Your Ref: OWQC19927
Our Ref: BE/81/18/PL
Please ask for:
Mr R Castro-Parker

Change of use of the property from dwellinghouse to mixed use dwellinghouse & attached building for the operation of a hairdressing business (A1) & retention of attached building.
324 Chichester Road Bersted

Thank you for your internet comments made on 6th September 2018 which has been recorded as **'an objection'** with the comments as follows:

Drawing 3 - Proposed Site Plan
Scale 1:200 @ A3

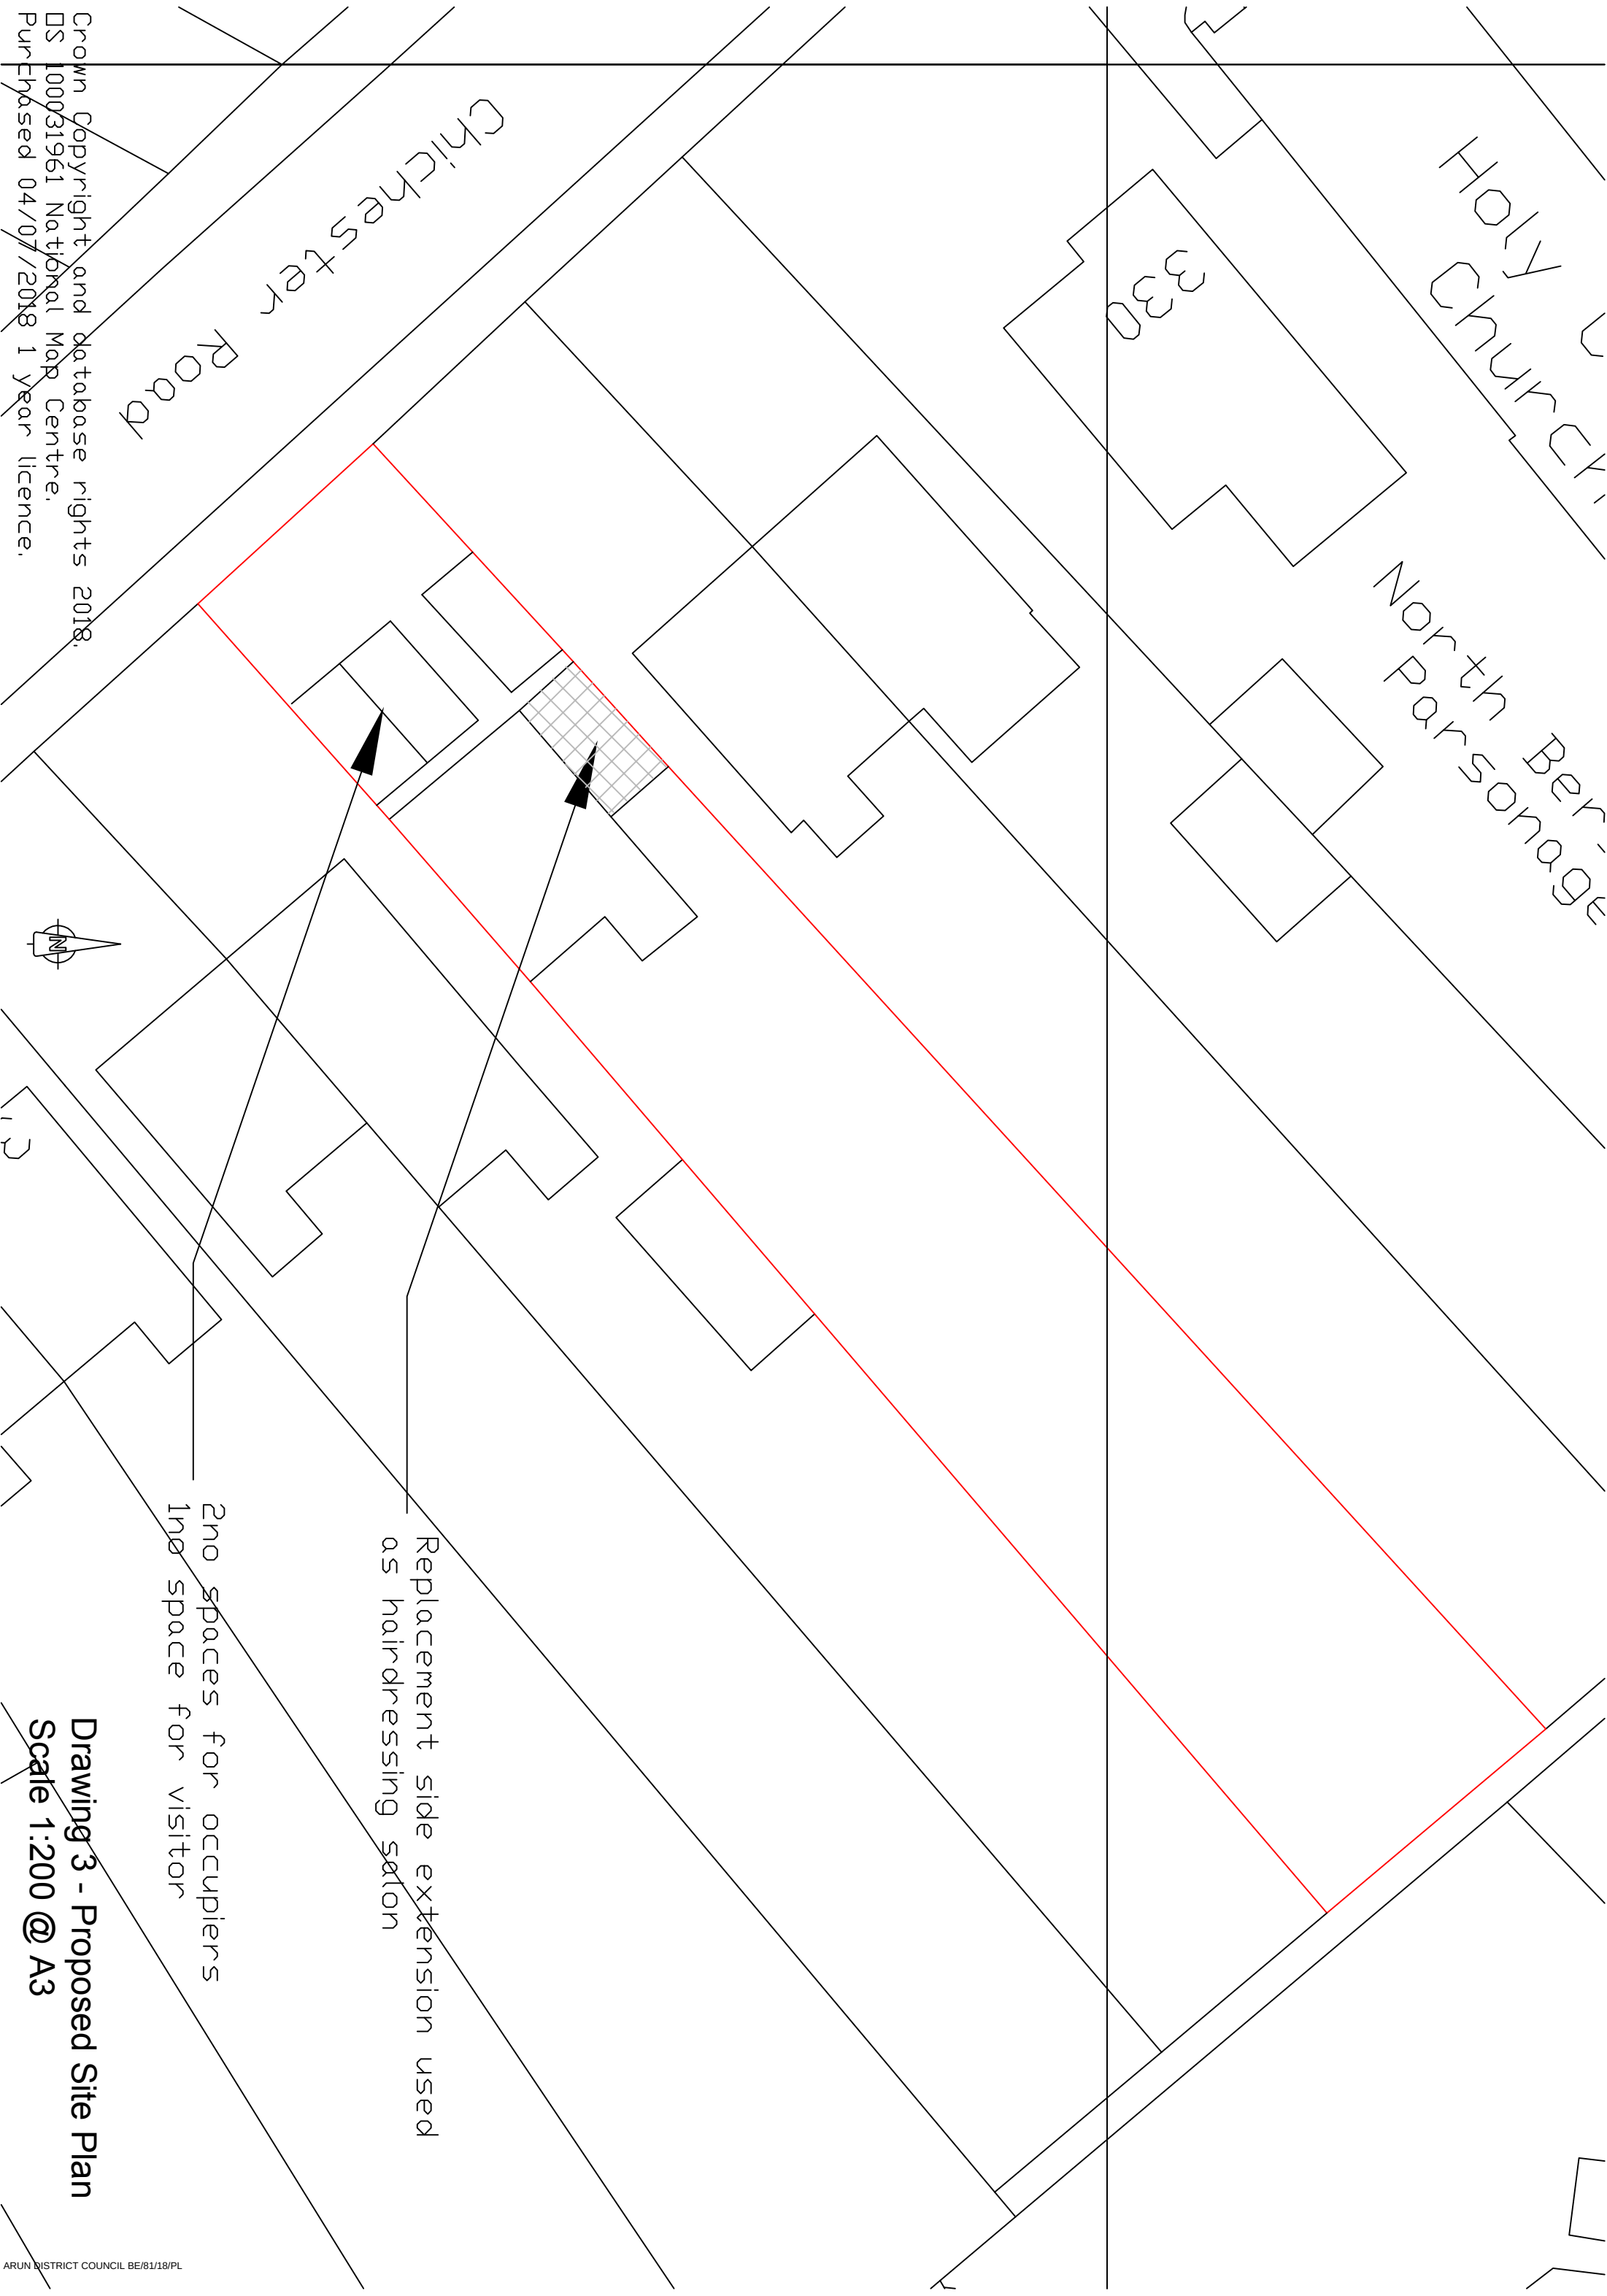
Highway Safety & Traffic. Cars reversing onto a main road as there is insufficient space for vehicles to turn onsite. Also setting a precedent for A1 use in a residential area could lead to more intensive use in the future.
